**Howerton Services, PLLC**  
**License # P-1716**  
3513 Cathedral Bell Road  
Raleigh, NC 27614  
(919) 270-3460

December 27, 2021

Subject: Dawson Residence  
565 Cotton Road  
Fuquay Varina, NC 27526  
Plan Revision Letter  
Harnett County Permit #: SFD2110-0007

SHEET # **A-3**

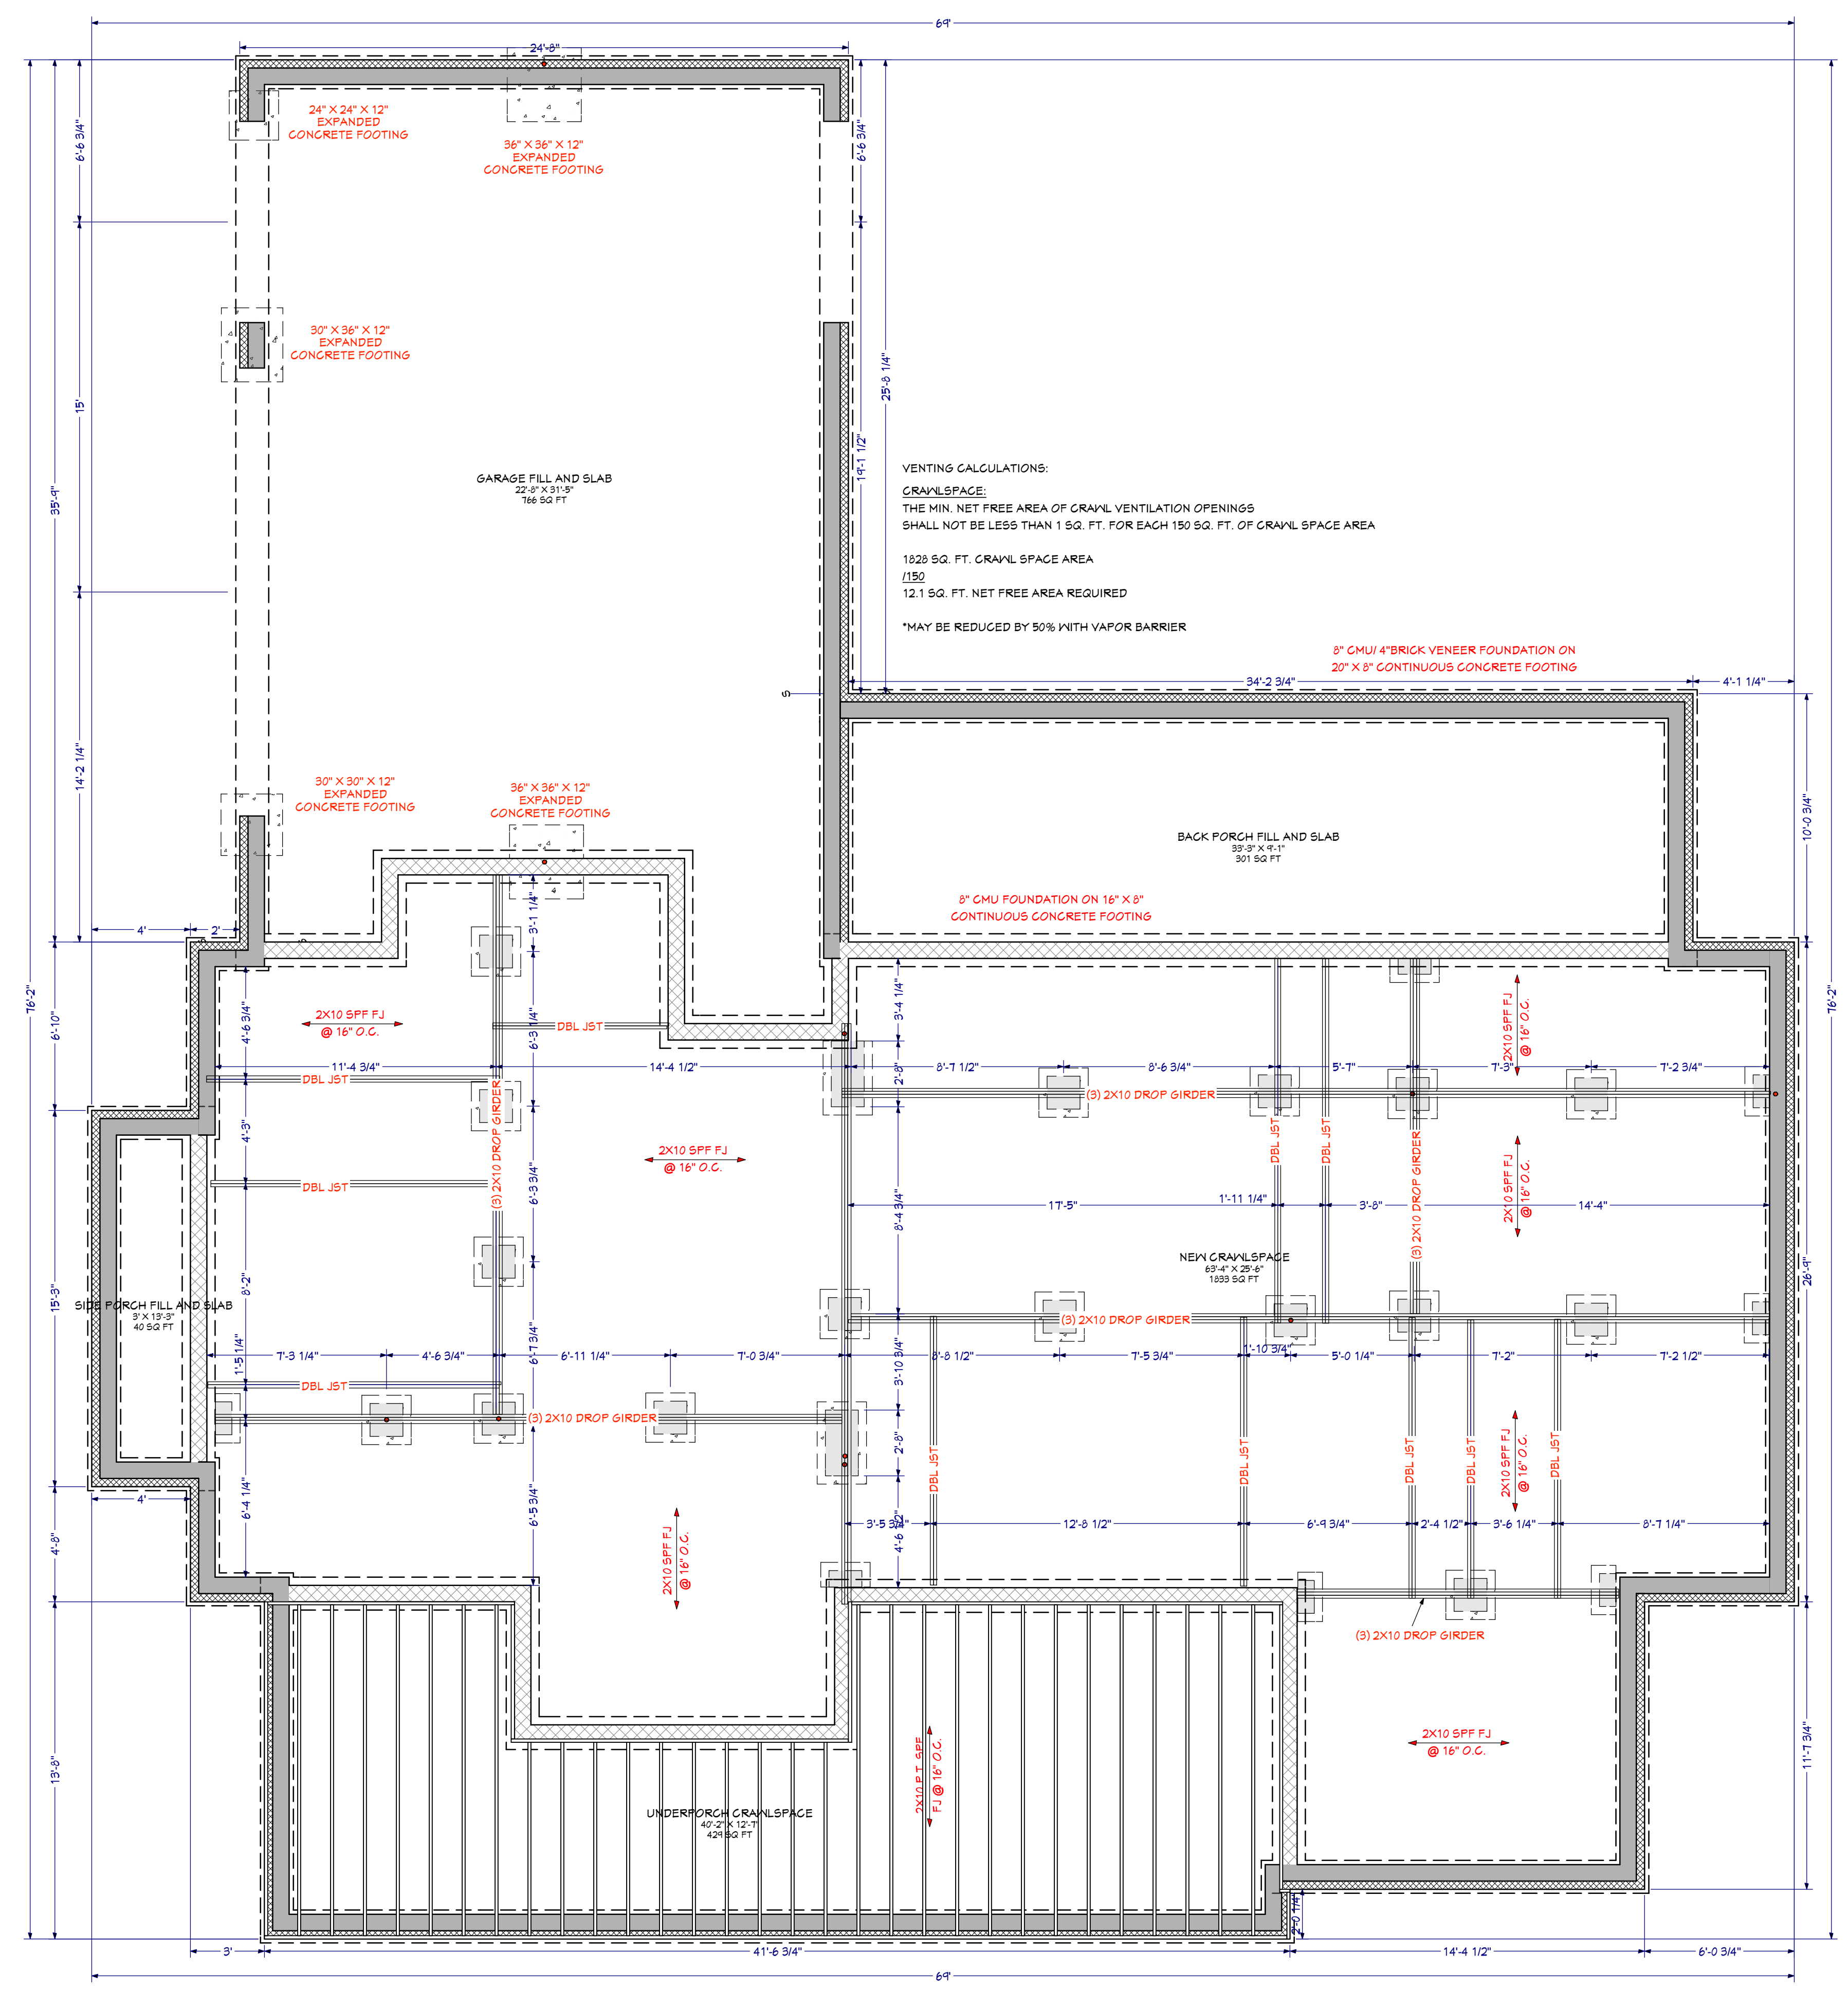
- In the notes for the Foundation Plan, sheet A2, the 2 - #4 bars continuously were specified to be placed in the footings. The rebar is not required to meet Code requirements. The rebar will not be installed in the footings.
- The continuous footings are noted to be 20" wide in all locations. The footing width may be modified to 16" where the foundation wall width is 8".
- There is an alternative set of plan sheets for the Garage. The alternate plan was previously designed and signed by me. The modified design will not have the stud wall between the single car and twin car section. A steel beam will span the entire width of the Garage. The Foundation plan sheet, A3 and the 1<sup>st</sup> floor plan sheet, A1 dated 09/14/2021 will be used for constructing the Garage.
